From: [REDACTED]@thurrockscouts.org.uk>
Sent: 22 January 2021 15:58
To: contact@thurrockpower.co.uk
Cc: Thurrock FPG <ThurrockFPG@planninginspectorate.gov.uk>
Subject: EN010092 - Thurrock Power Generations

Dear Mr Andrew Troup,
I writing to you in response to your letter to Condovers Scout Activity Centre dated 7th December 2020.

I am a volunteer with Thurrock Scouts, and I am looking into any potential impact on the Condovers Scout Activity Centre with the proposed application by Thurrock Power, EN010092 - Thurrock Power Generations

Figure 2.1: Most-affected receptors from construction and operational noise effects from Thurrock Flexible Generation Plant.

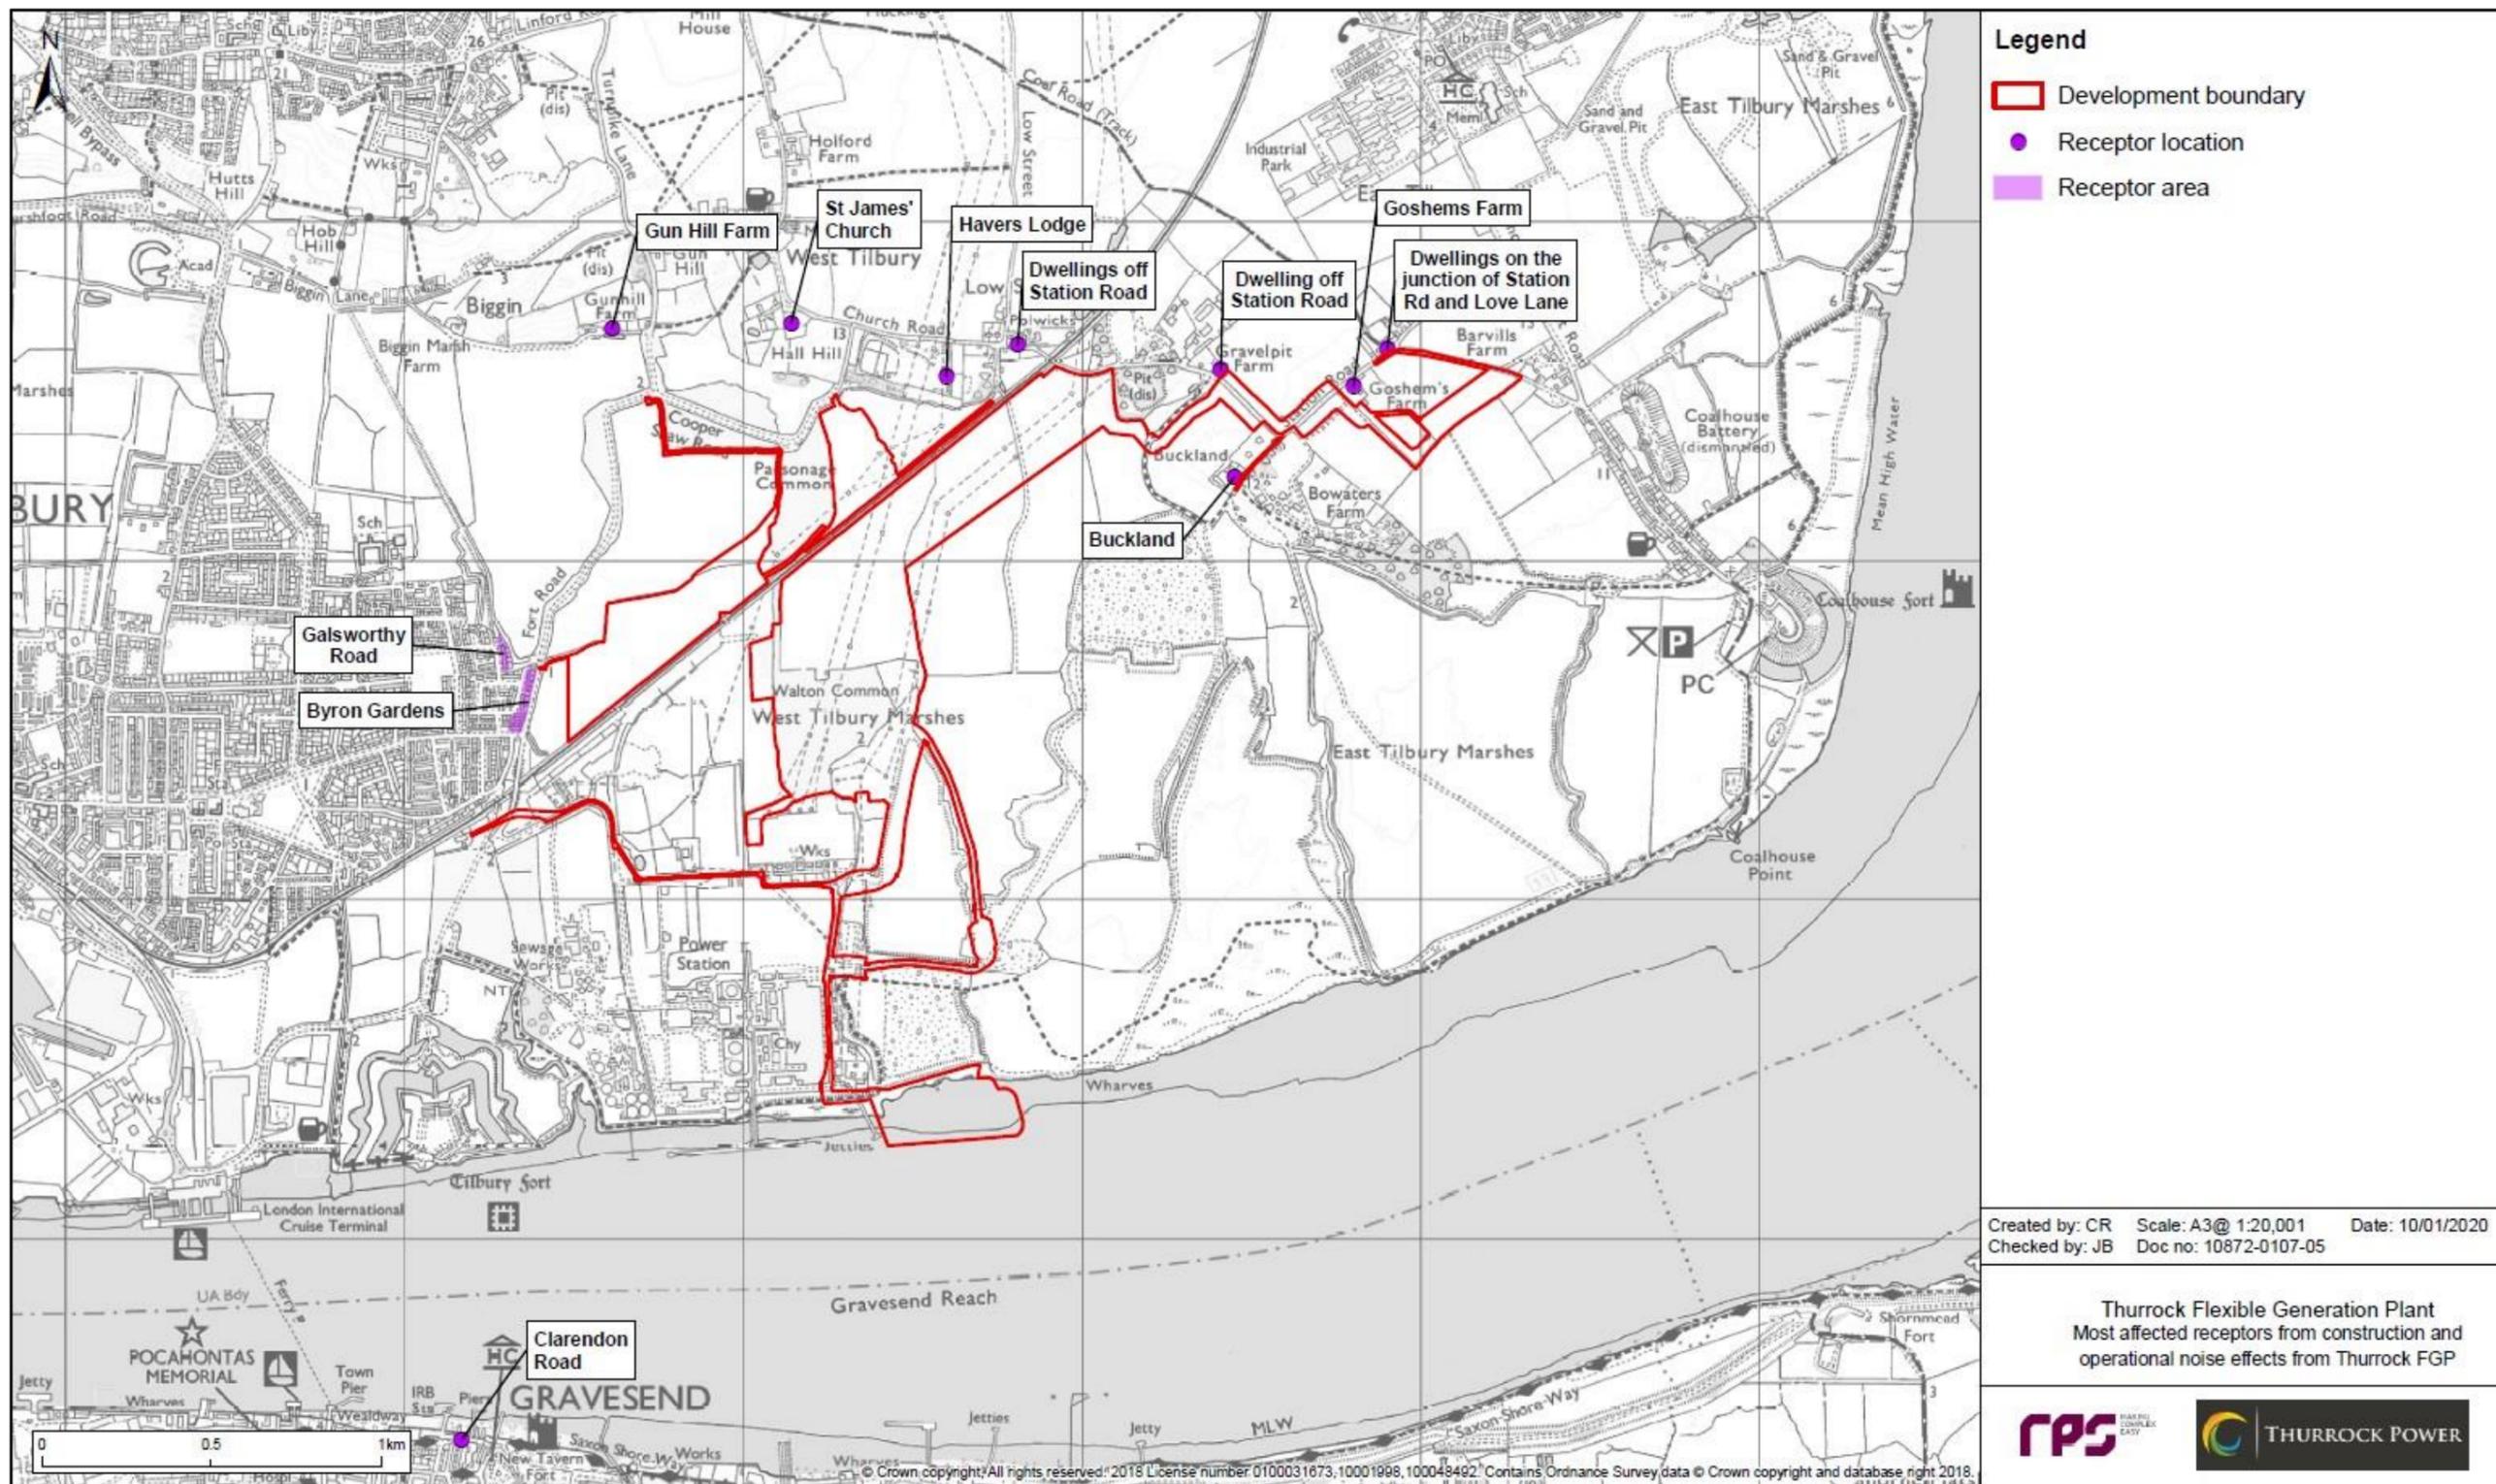
*Condovers Scout Activity Centre has been operating on this site since 1948 and does not appear to be detailed on the maps in the planning documents. **Havers Lodge, which is located on Condovers, is mentioned in section 1.1.6 of Chapter 2: Project Description Environment Statement as a residential property, this is incorrect.***

- Additional HGV traffic on Church Road during construction, a very narrow country lane*
- Road and footpath closures during construction, which would impact our members, living in the east of the borough, access to Condovers.*
- Road and footpath closures during construction, which would also impact on short hikes/rambles for our youth members which start and end from Condovers.*
- The environmental impact, noise, and air quality on Condovers, during the construction of the gas pipeline and permanent access road in zone C, parallel to the railway line.*
- The environmental impact, noise, and air quality during operation of the generation plant, on Condovers.*

Figure 1.51.6: Development zones.

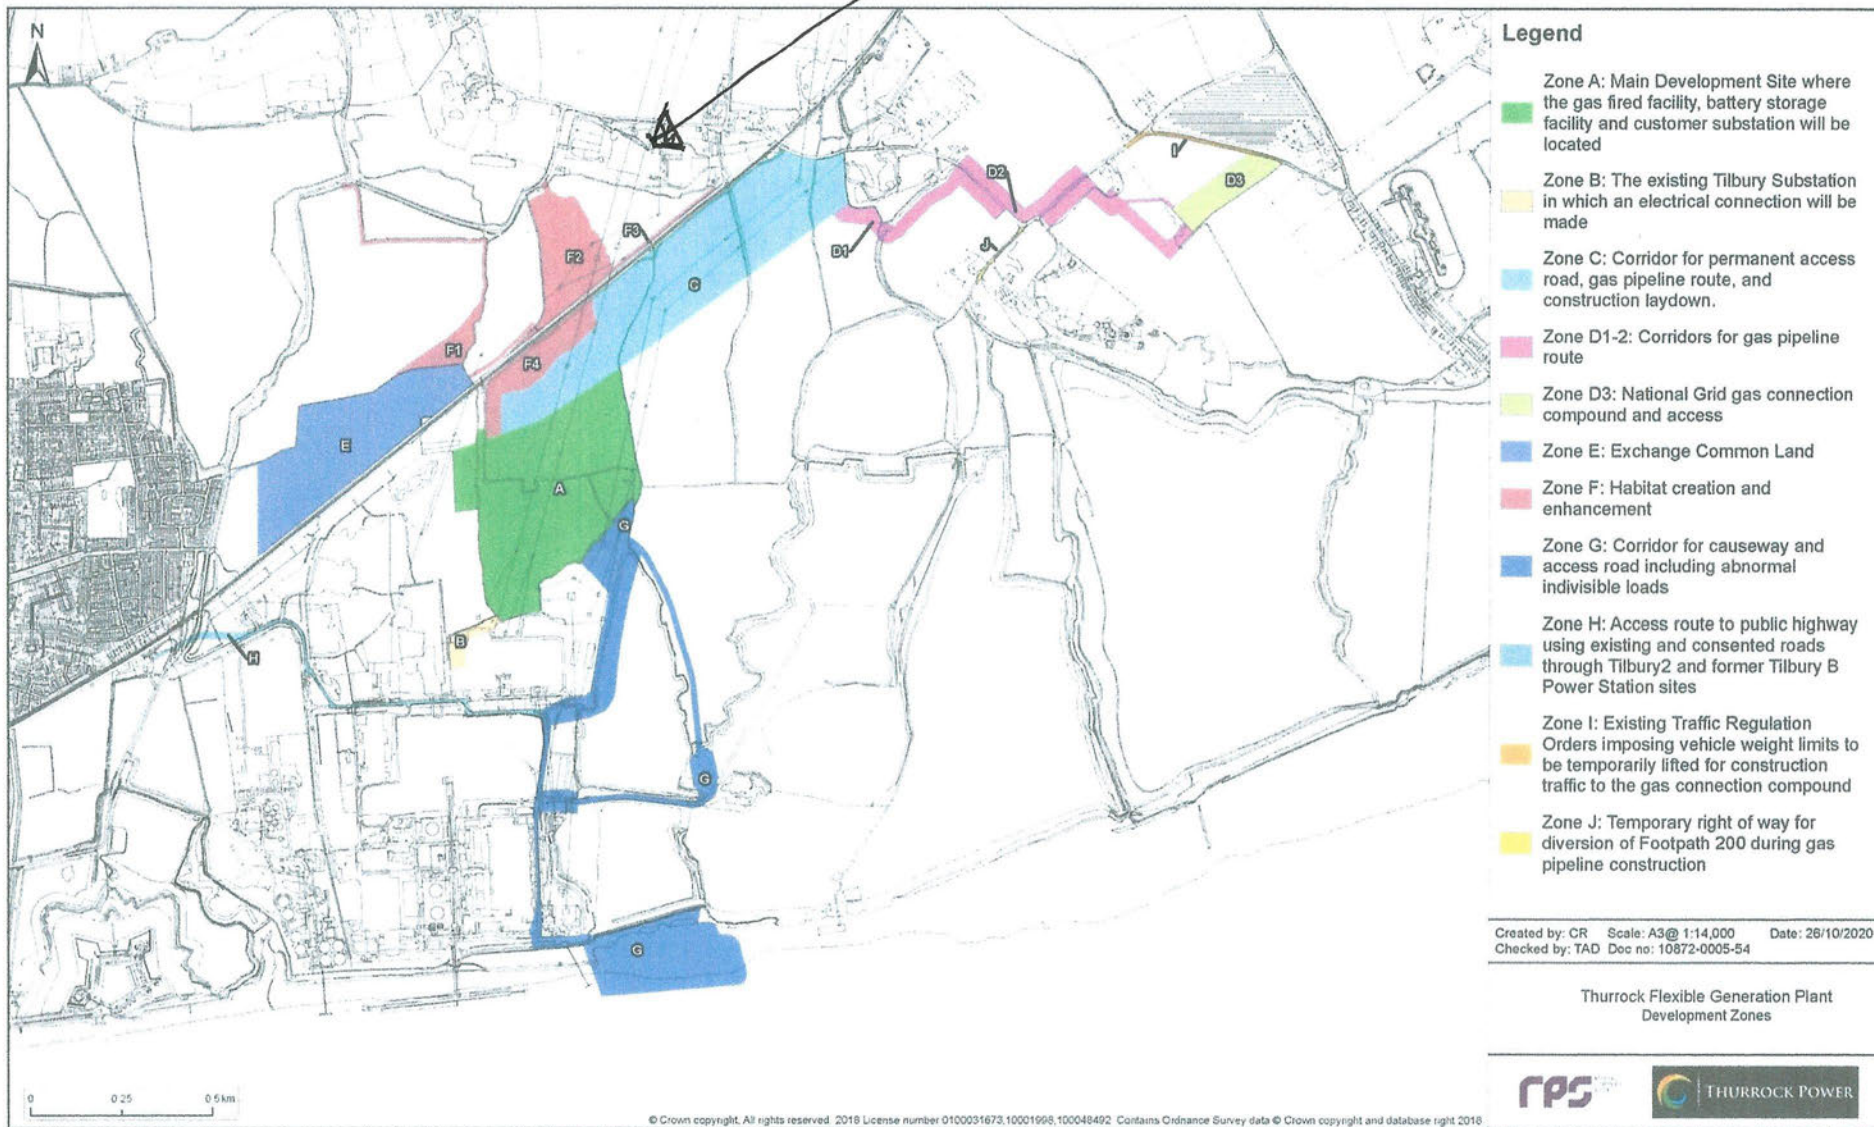
I have reviewed the latest revised Environmental Statement and I note that Condovers Scout Activity Centre (Condovers) is still being referred to as Havers Lodge (just one of our buildings) and is being grouped with residential properties.

Condoverters does not have any residential properties on their site and we are registered for Business rates as a charitable educational (unclassified) activity centre.

I would be grateful if the Environmental Statement could be updated to reflect the sites activities and the potential impact, of the proposed development, on our 3.5acre site.

I have attached a plan showing our activity centre in relation your published development zones.
